From: [Michael Dierdorff](#)
To: [Deb Estrada](#); [Michael Dierdorff](#)
Subject: Questions Regarding "Notice of Public Hearing-SUB19-002 "Tree Issues"
Date: Wednesday, January 24, 2024 8:58:05 AM

Subject: Questions Regarding "Notice of Public Hearing-SUB19-002"

PRELIMINARY GRADING PLAN
2825 W MERCER WAY
PRELIMINARY PLAN
 PARCEL #2174502425
 CITY OF MERCER ISLAND WASHINGTON

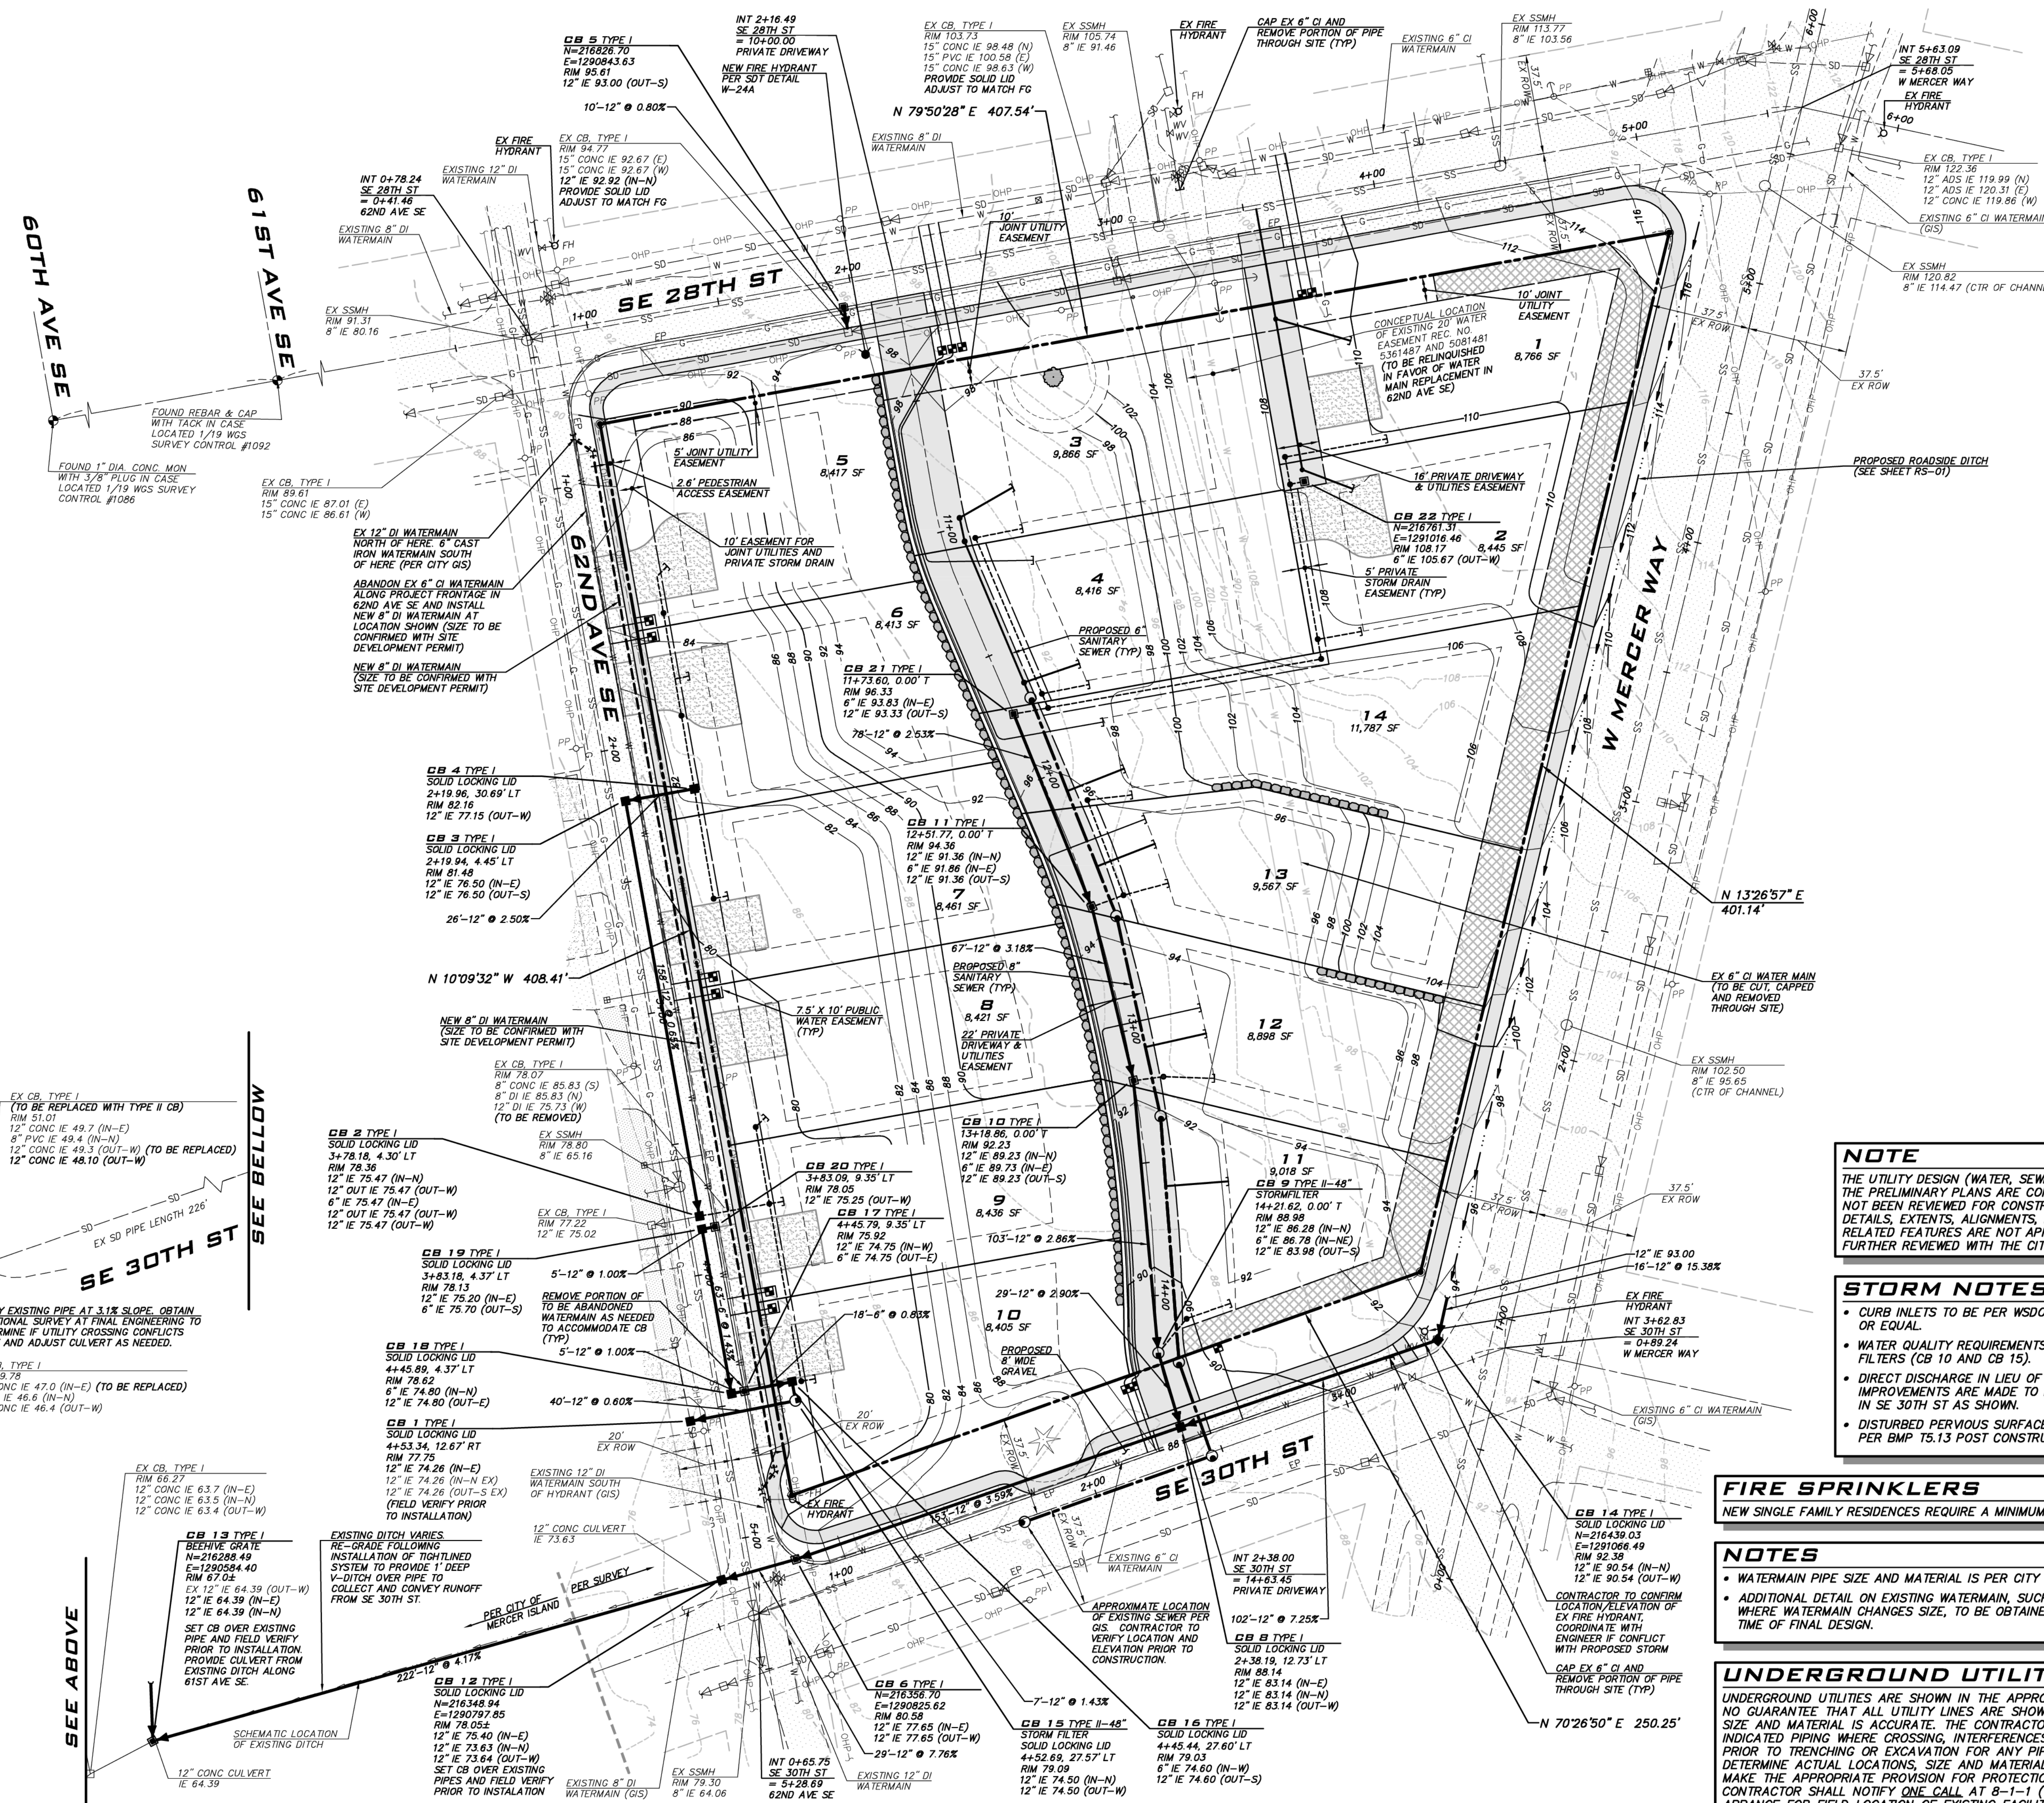
1. Will the current land grade be increased? I own two homes directly East of this project and don't want to increase the height of dirt thus increasing the height of the homes.
2. Will each house have 2 car garages and or will street parking outside of the complex be restricted. Prefer not to see cars parking on streets.

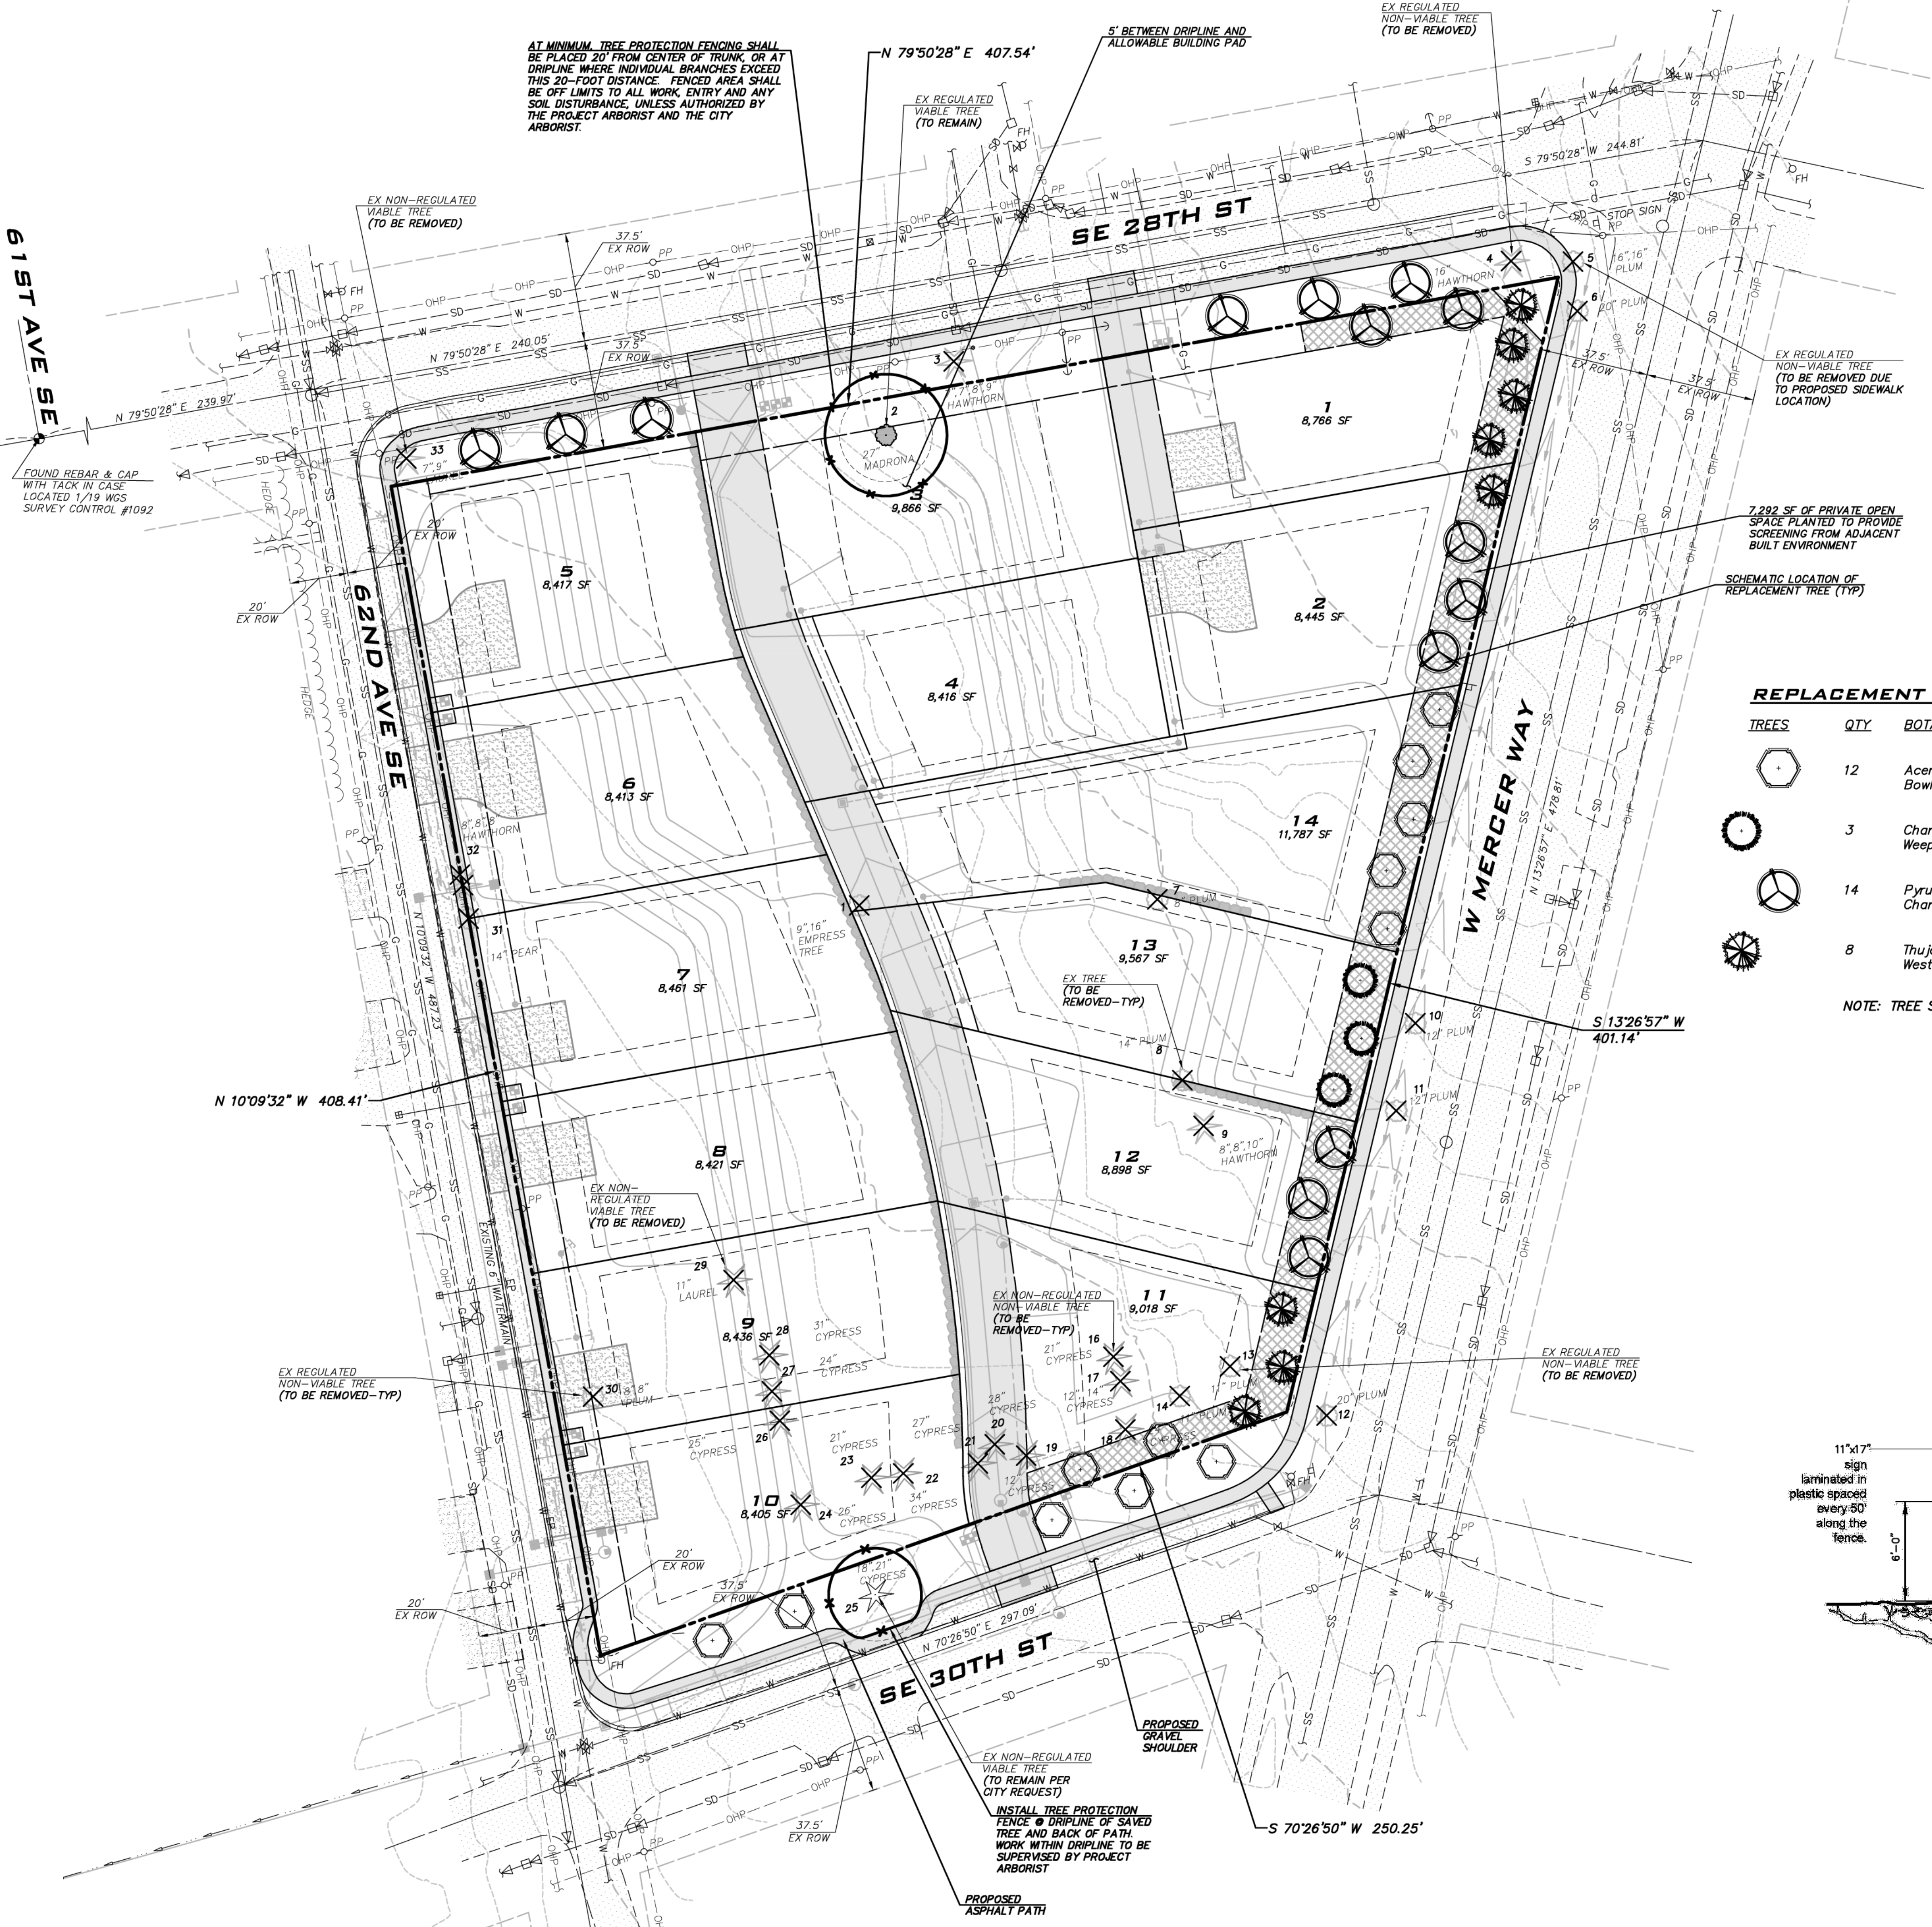
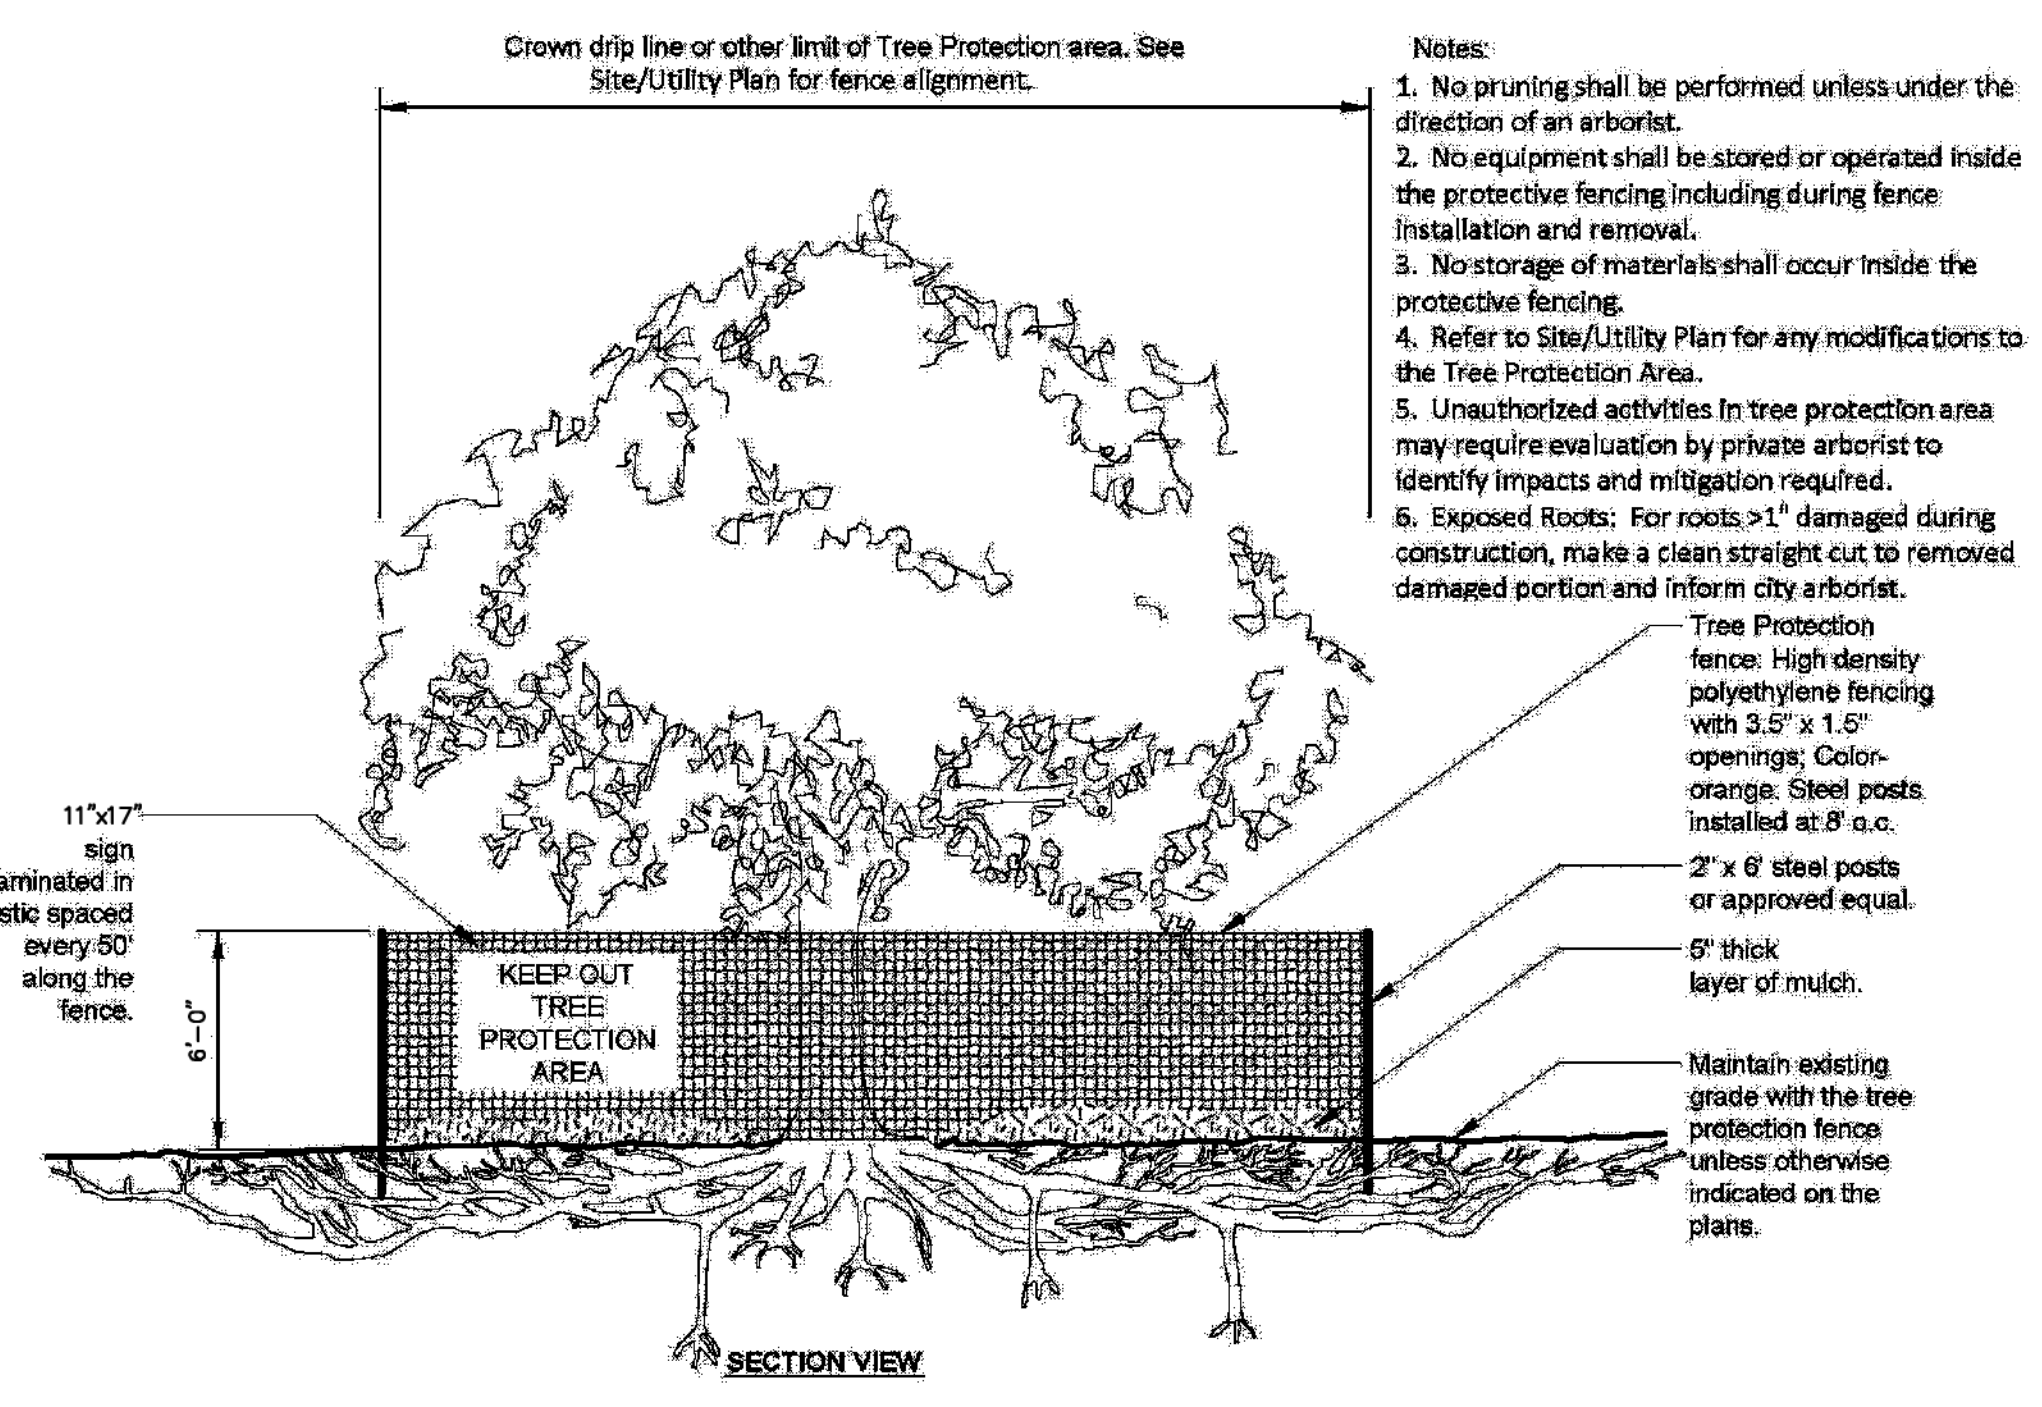
Regarding today's meeting at 9:00 am I want to make the following comments. I have two homes directly across the street on the East side of this project. I look West to Seattle. I see the project calls for approximately 22 trees along West Mercer most of which are between 35-45' tall. I am concerned these trees will obstruct our views and will be taller than the homes themselves. I like the looks of the proposed trees except for the Weeping Nootka False Cypress. The three Cypress are the only ones of that style and are an odd addition in my opinion. I also don't want to look at anything "weeping" especially in this gloomy time of year. The other trees requested have nice color and foliage. For all trees can the arborist find similar looking trees in the 20' height limit?
